To: FILE
From: Nell Donaldson
Subject: Application ID: 2014-220
Date: 3/19/2015

Comments Submitted by: Craig Messinger/Fire on 2/23/2015

2 HYDRANT DETAIL
C4.1 NOT TO SCALE

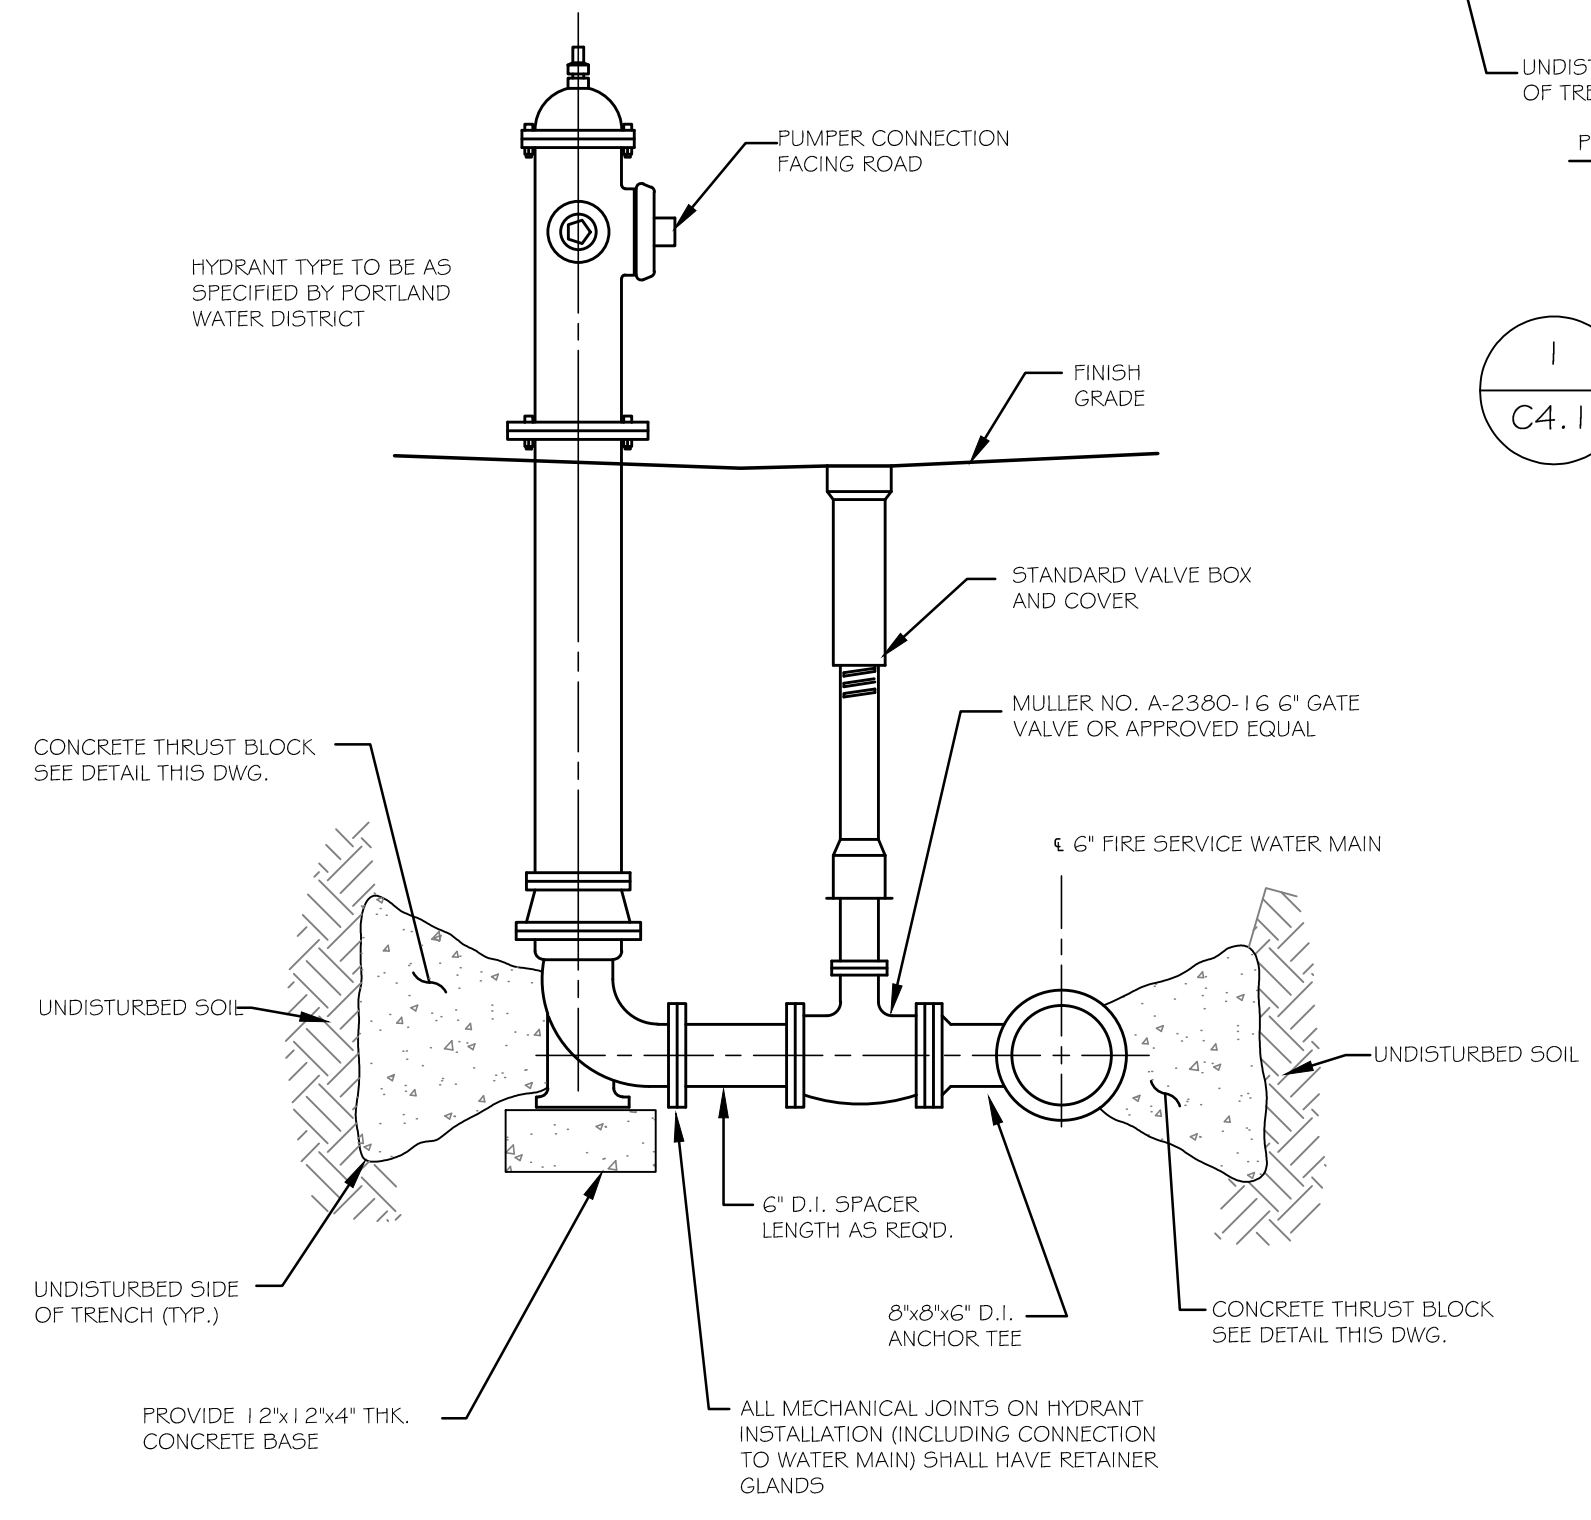
Hi Nell,
Thanks for revised plans, I can see where they relocated the fire hydrant and seems to be fine.
Would you please add the following to the conditions:
Private hydrants shall be maintained and cleared of snow during the winter months.
Private hydrants shall be painted as follows: Bonnet-gray, caps-silver, Barrel-red.
Please call me if you have any questions,
Thanks Craig
